Comments from Greenspace

NOTIFICATION FROM ARUN DISTRICT COUNCIL
Town & Country Planning Act 1990 (as amended)
Town and Country Planning (Development Management Procedure)
(England) Order 2015
Planning Permission
APPLICATION **BN/43/16/PL**
NO:

Registered: 24th August
 2016
Site Address: Angels Nursery Yapton Road Barnham PO22
 0AY
Grid Reference: 496239 104131
Description of 95 No. dwellings together with access,
Works: landscaping open space & associated works.

Fig 2: Proposed layout

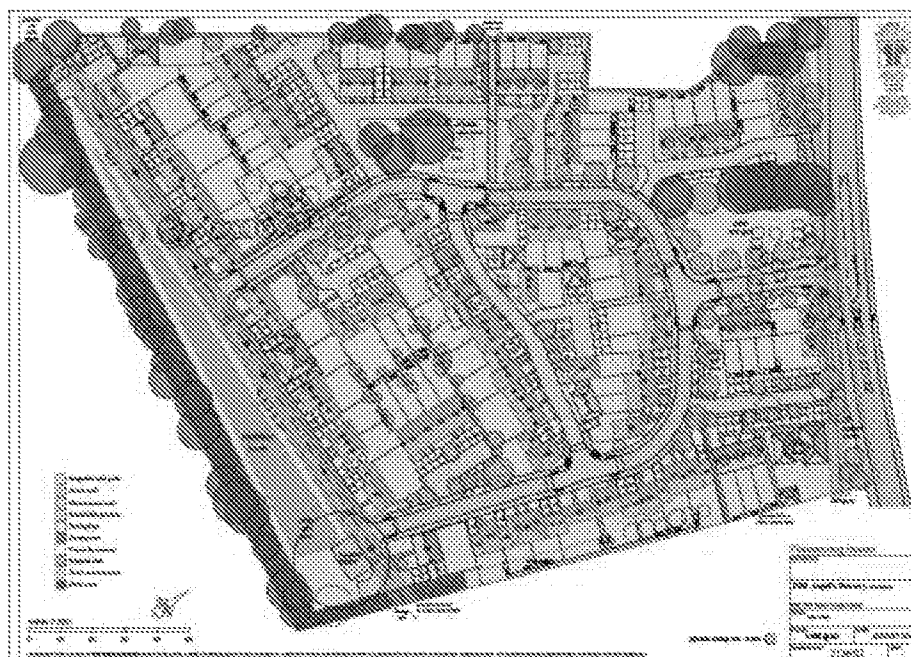
Developments of 10-200 dwellings or more are expected to provide open space on site. The Council's SPG guidelines which apply to developments of houses and are based broadly upon the National Playing Fields Association's (NPFA) "Six Acre Standard". Under superseded Fields in Trust guidelines (FIT) this requires that 3.2 hectares of open space are provided for every 1,000 people ie 32 square metres of open space per person. We would require confirmation of the areas of public open space being proposed with this development. As there are 95 dwellings proposed for this site, then provision of LAP and LEAP would be sought on site with the addition of Multi-Use Games Area (MUGA) contribution being sought. The present details indicate an on-site open space provision of 4652m², however 2289m² of this is indicated as retention basin and would not be suitable as open space. The open space indicated at present does not meet the minimum requirements.
